Harnett County Government Complex  
307 W. Cornelius Harnett Boulevard  
Lillington, NC 27546

**Re: Status of Improvement Permit Application #09-5-22516**

SILVERADO HOMES, LLC.
 THE JACKSON
 LOT # 99 ASHEFORD
 SCALE: 1"=40'

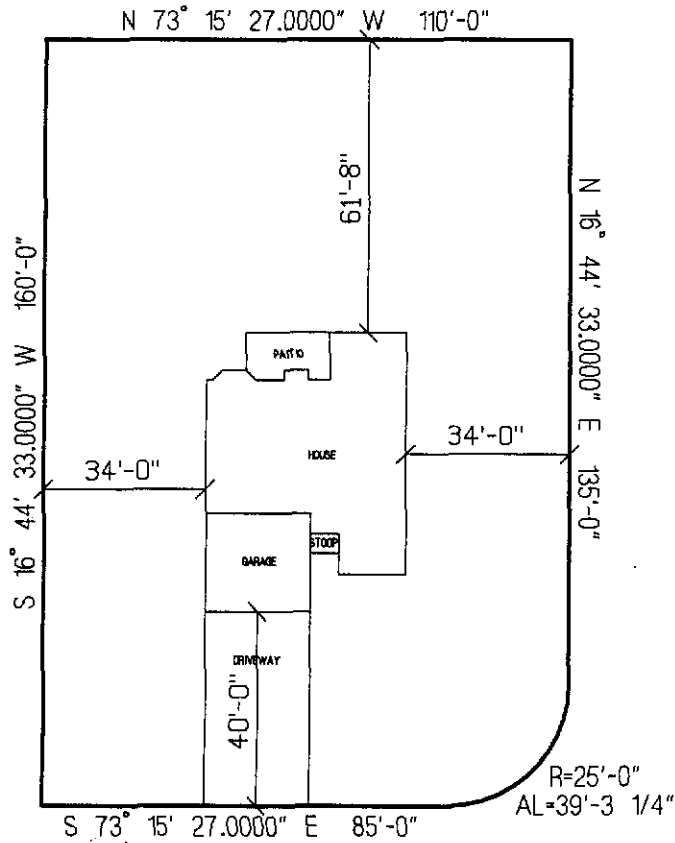
- 1. Property lines/corners not marked or labeled (*\$25.00 fee incurred*)
- 2. House corners not marked or labeled (*\$25.00 fee incurred*)
- 3. Directions not clear to property (*\$25.00 fee incurred*)
- 4. Property needs brush or vegetation removed
- 5. Backhoe pits required
- 6. **Other – Need revision on site plan (move house forward 5 feet)**
